Thank you for the opportunity to comment on the short plat of approximately 20 acres into 2 lots, proposed by Marcus Menzel [SP-09-00007]. We have reviewed the application and have the following comments.

SUBJECT: Menzel Short Plat SP-09-00007

RE: Wheeler/Menzel Short Plat SP-09-00007

WHEELER SHORT PLAT
A PORTION OF THE NE 1/4 OF SEC. 7, T.17N., R.18E., W.M.
KITTITAS COUNTY, WASHINGTON

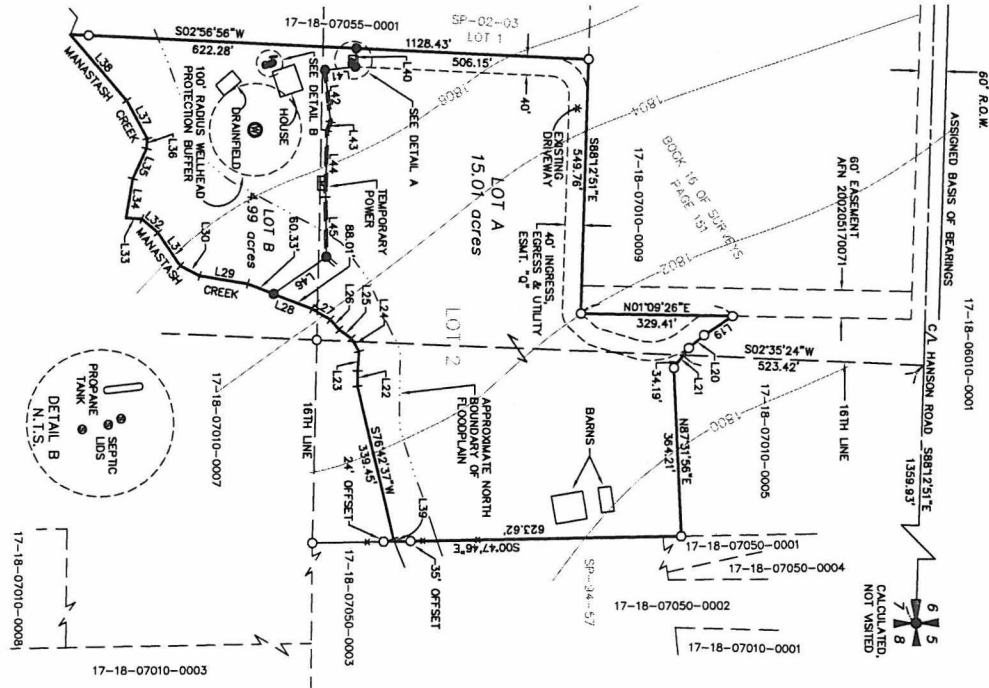
1. Joint-Use Driveway: A joint-use access shall serve no more than two tax parcels. See Kittitas County Road Standards, 9/6/05 edition.
 - a. Access easements shall be a minimum of 20' wide. The roadway width shall have a minimum width of 12'.
 - b. The surface requirement is for a minimum gravel surface depth of 6”.
 - c. Maintenance of driveway approaches shall be the responsibility of the owner whose property they serve. The County will not maintain accesses.
 - d. Any further subdivision or lots to be served by proposed access may result in further access requirements.

Single-Use Driveway: A single-use access shall serve no more than one lot. See Kittitas County Road Standards, 9/6/05 edition.

- a. The roadway shall be a minimum of 8' wide with gravel surface.
- b. Maintenance of driveway approaches shall be the responsibility of the owner whose property they serve. The County will not maintain accesses.
- c. Any further subdivision or lots to be served by proposed access may result in further access requirements.

2. Plat Notes: Plat notes shall reflect the following:
 - a. Maintenance of the access is the responsibility of the property owners who benefit from its use.

- b. An approved access permit will be required from the Department of Public Works prior to creating any new driveway access or performing work within the county road right of way.

- c. Any further subdivision or lots to be served by proposed access may result in further access requirements. See Kittitas County Road Standards.
 - d. A public utility easement 10 feet in width is reserved along all lot lines. The 10 foot easement shall abut the exterior plat boundary and shall be divided 5 feet on each side of interior lot lines. Said easement shall also be used for irrigation.
